Engineers Comments Regarding Surface Water Drainage

Application Reference:	A/20/26/DOC	Reviewer Reference:	ADC/EXT5/AF
Planning Officer:	Jessica Riches	Date of Review:	26/02/2026
Site Name:	Land North of Water Lane Angmering BN16 4EJ		
Application Description:	Approval of details reserved by condition under A/248/21/PL relating to condition 29 -As Built Drainage.		
Assessment Number:	1

Response	Condition 29: Further information required
-----------------	---

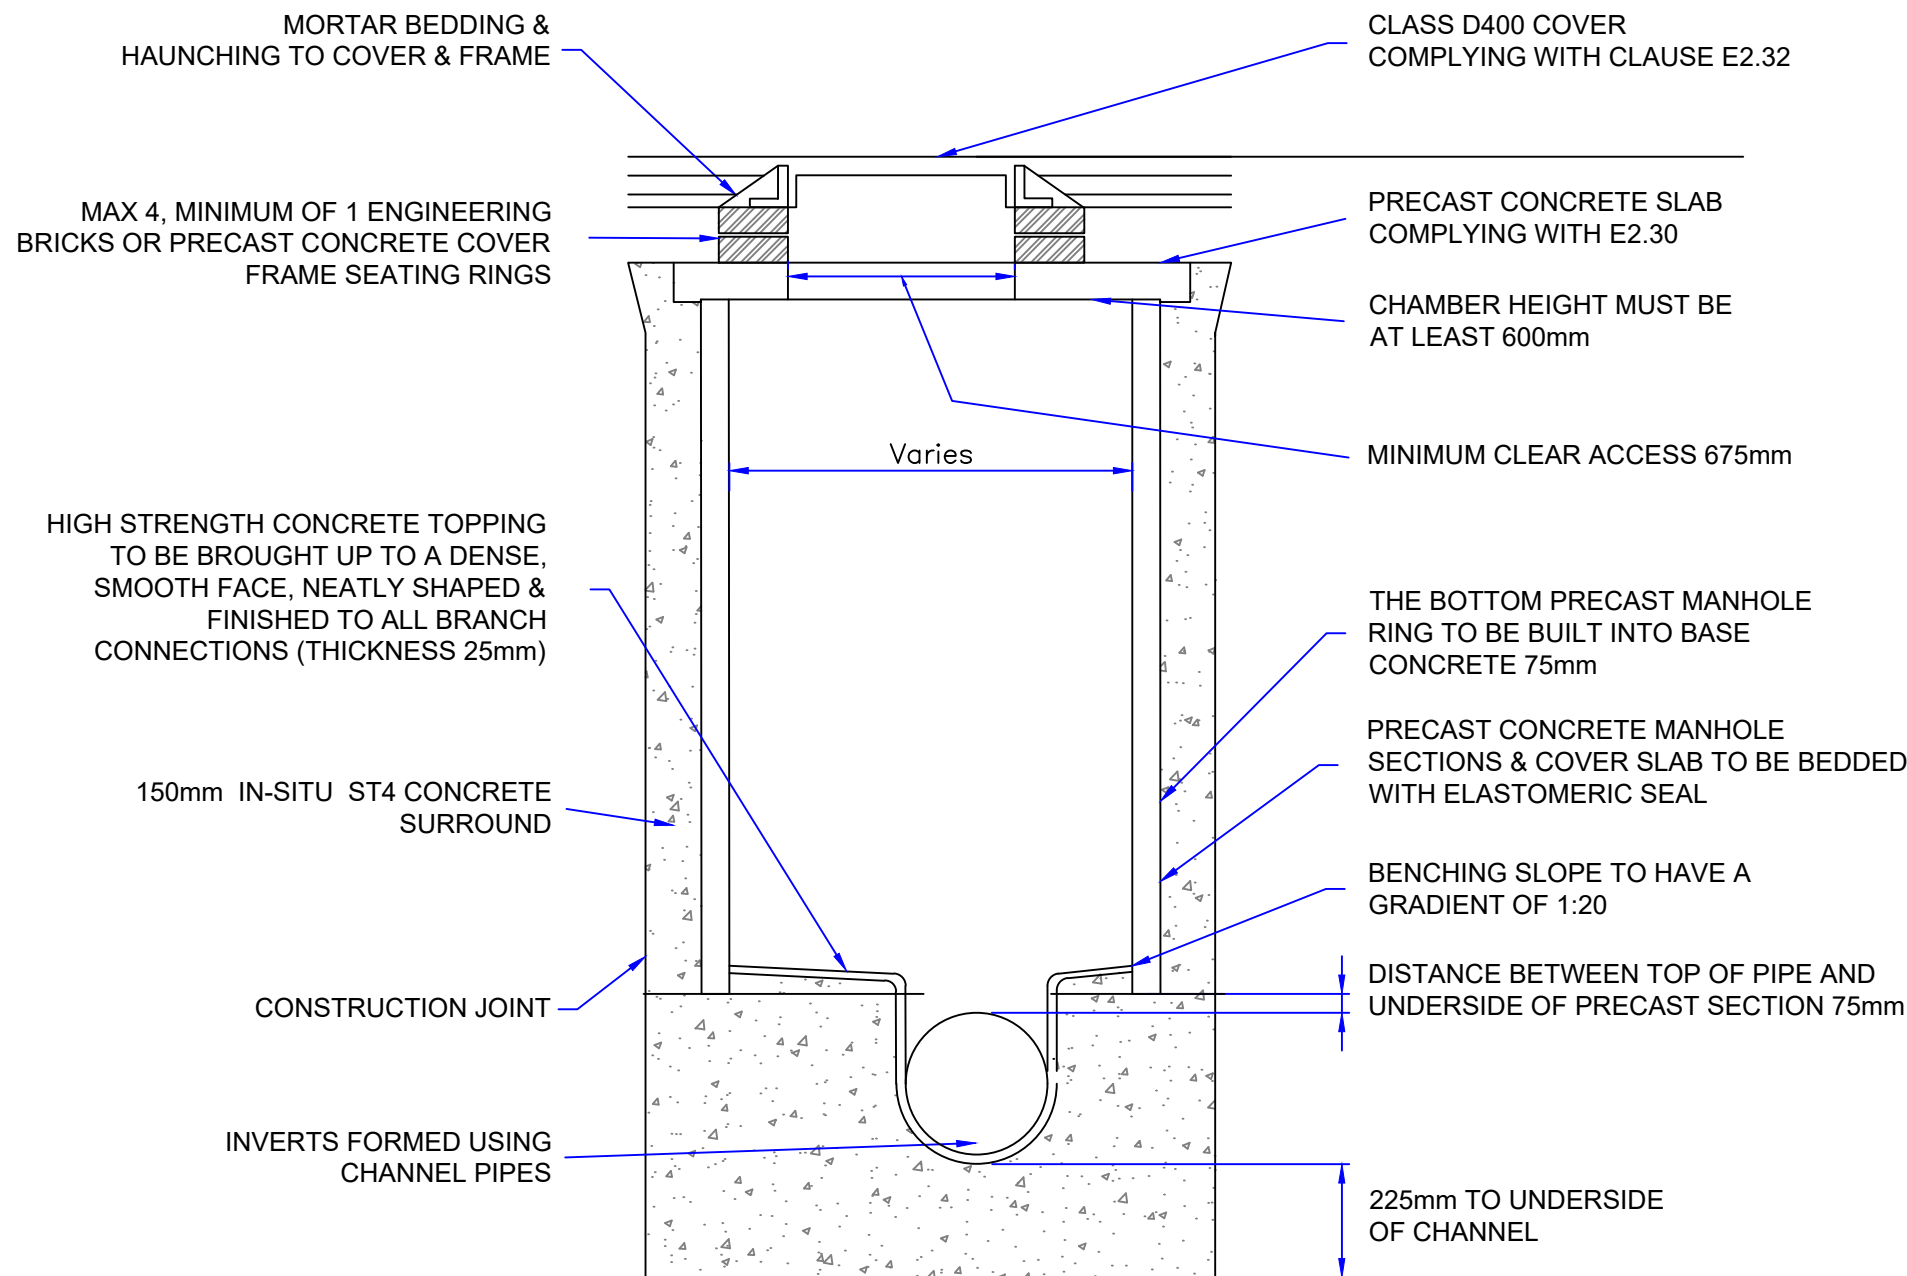
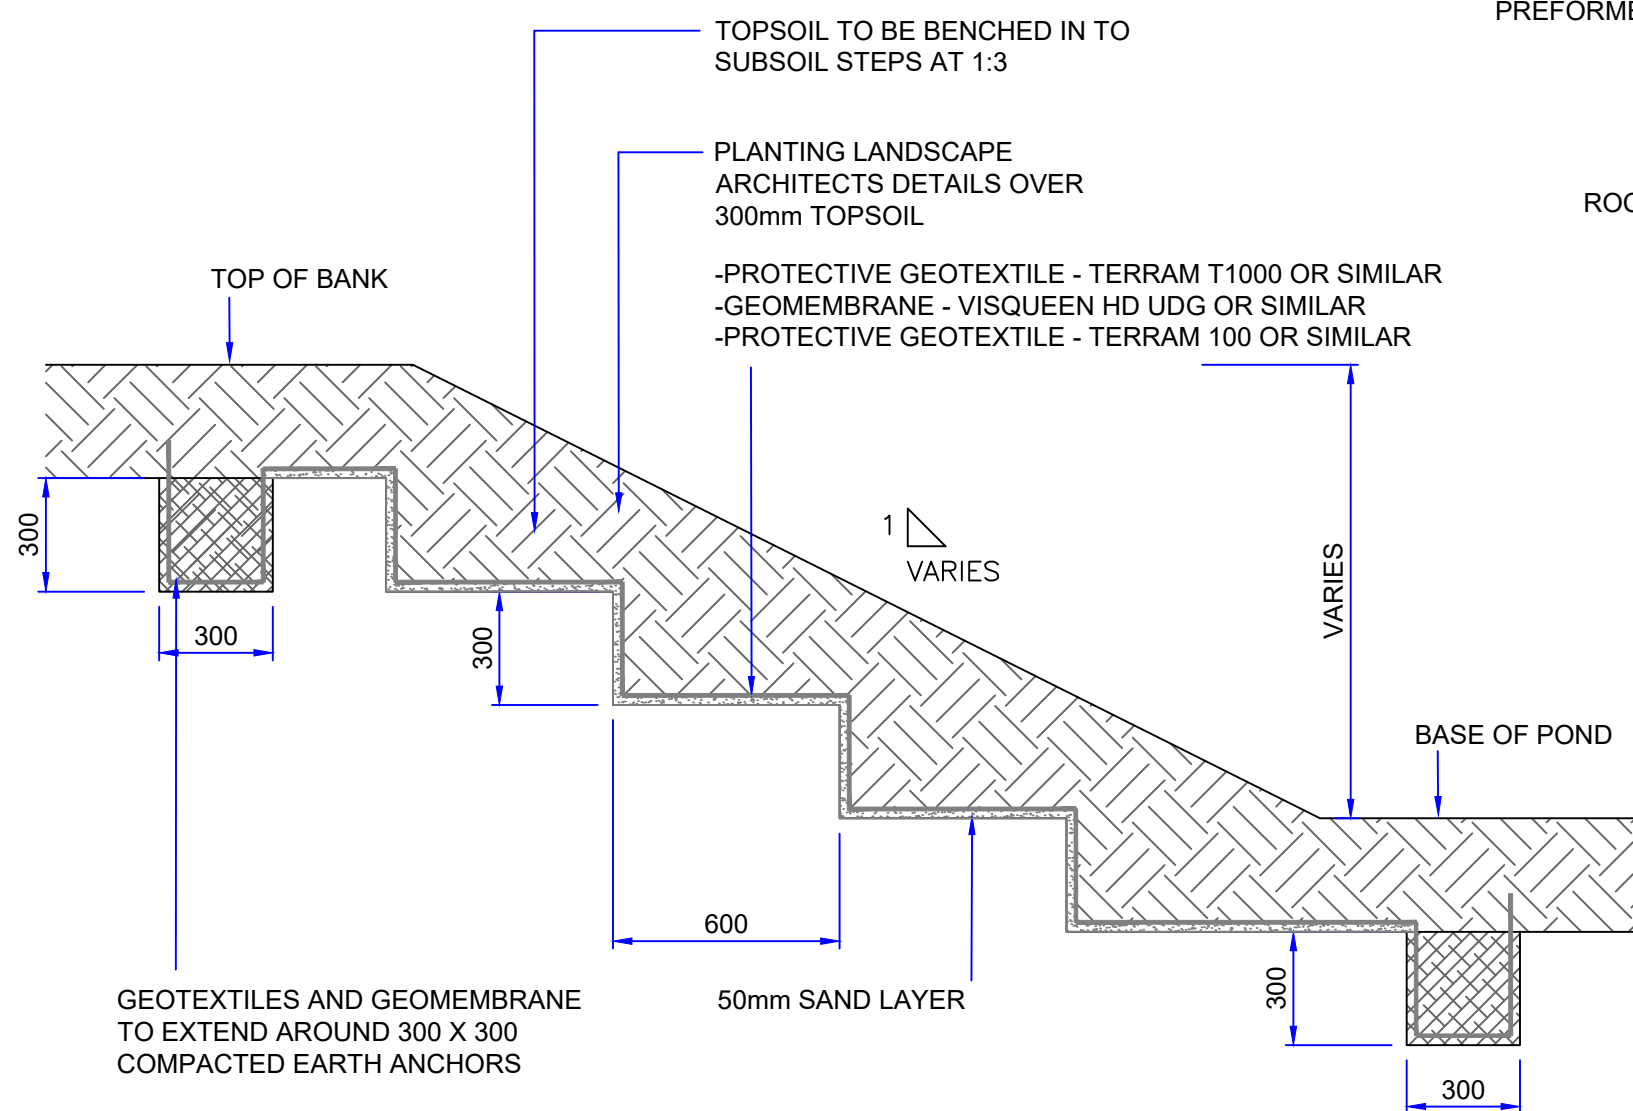
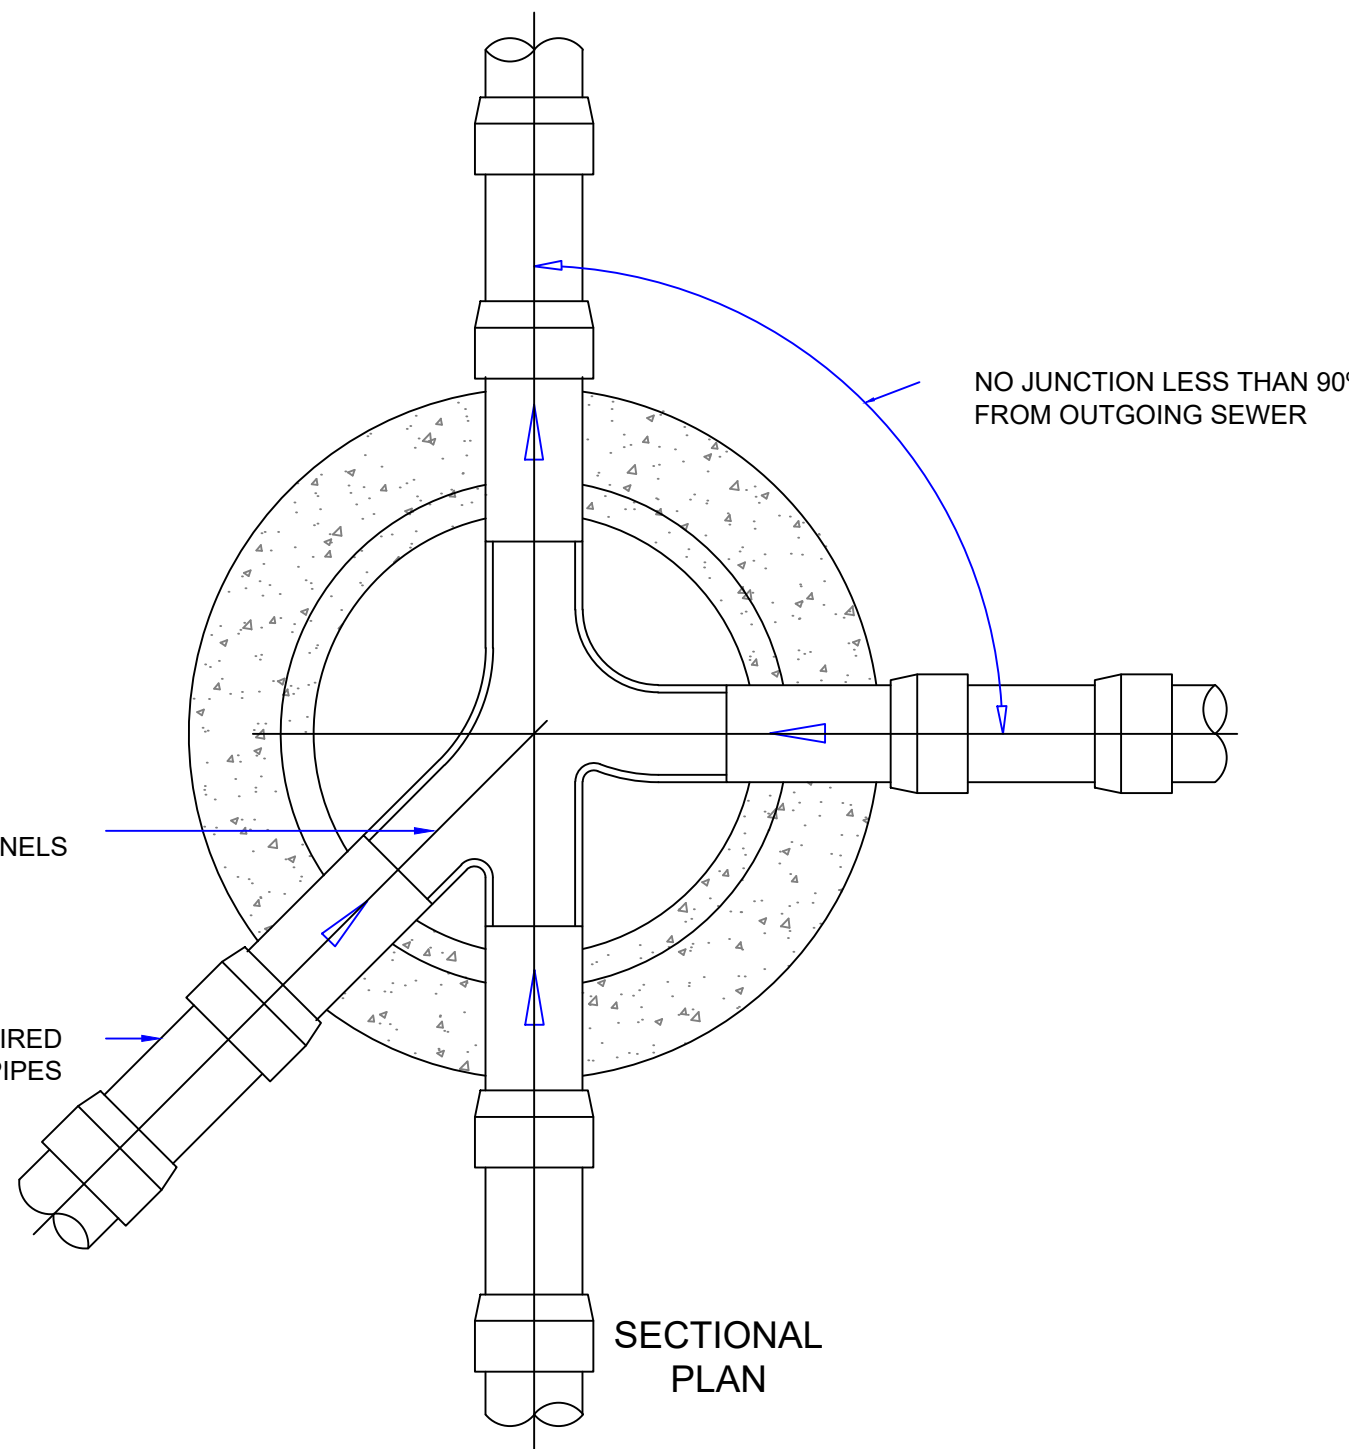
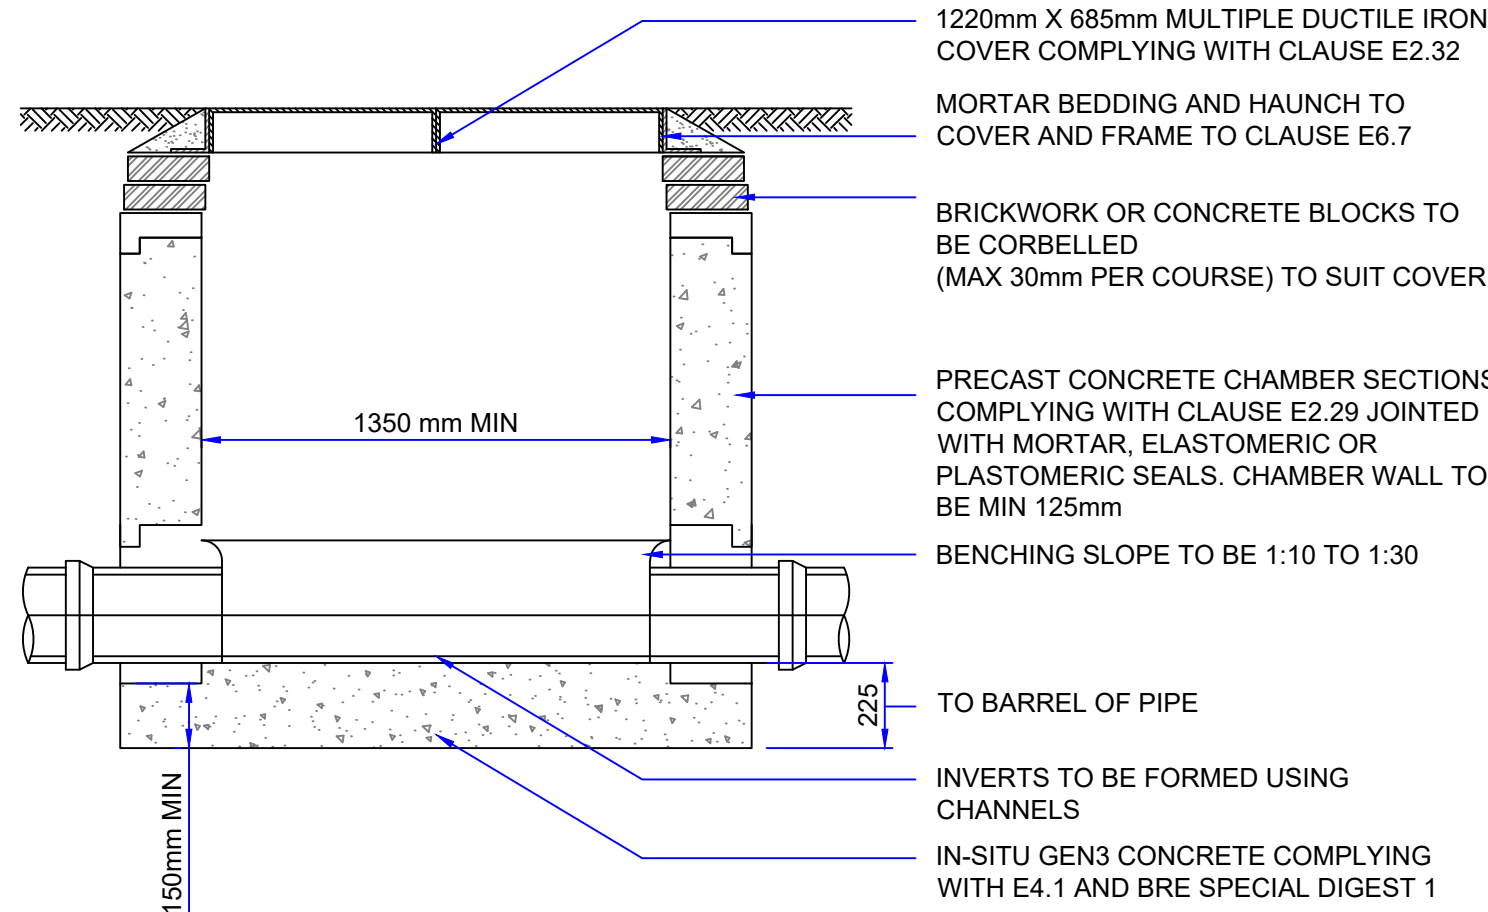
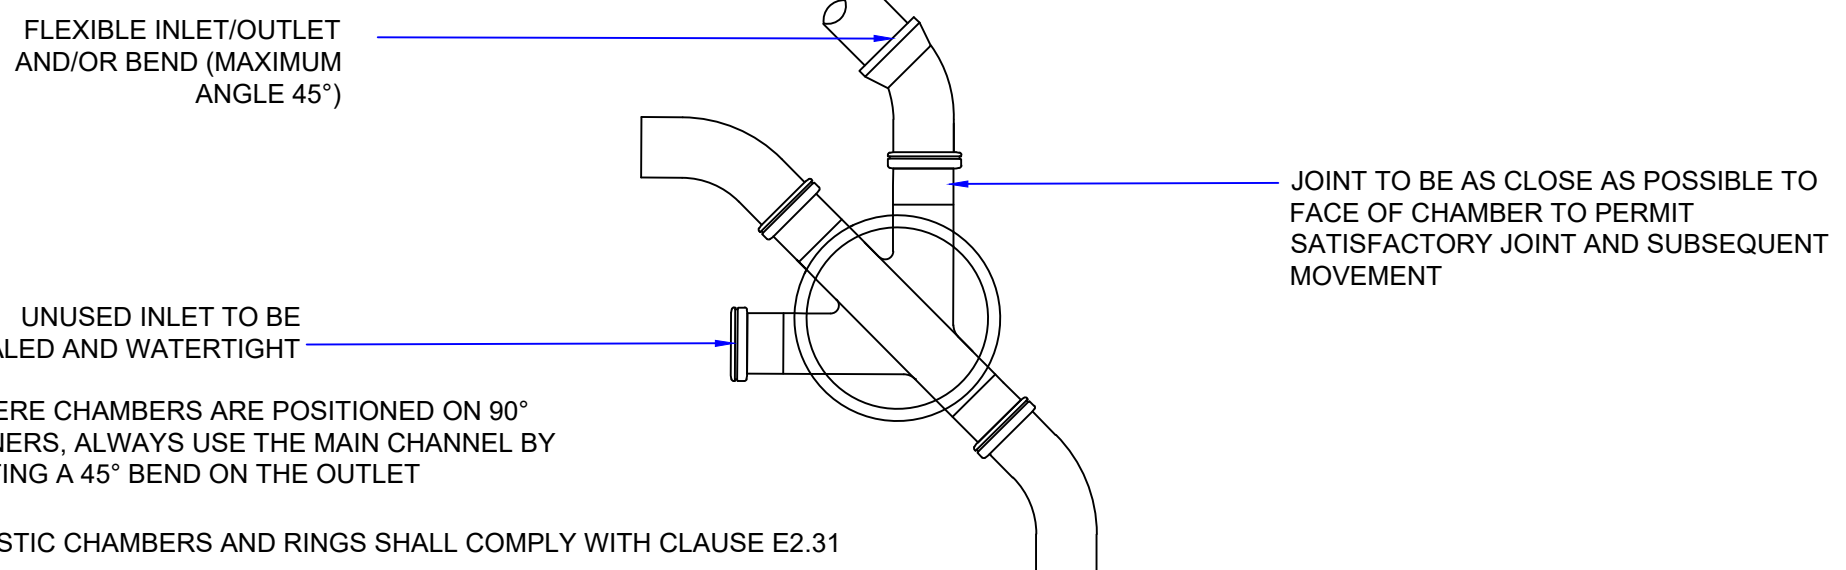
6.	The photos of the swales and headwalls are not referenced to the plans / location and it is not clear whether all infrastructure is shown. Photos should be referenced to locations on a plan.

7.	Photos were taken during unfinished construction and additional photos should be provided which evidence successful completion of the swale and headwall works.
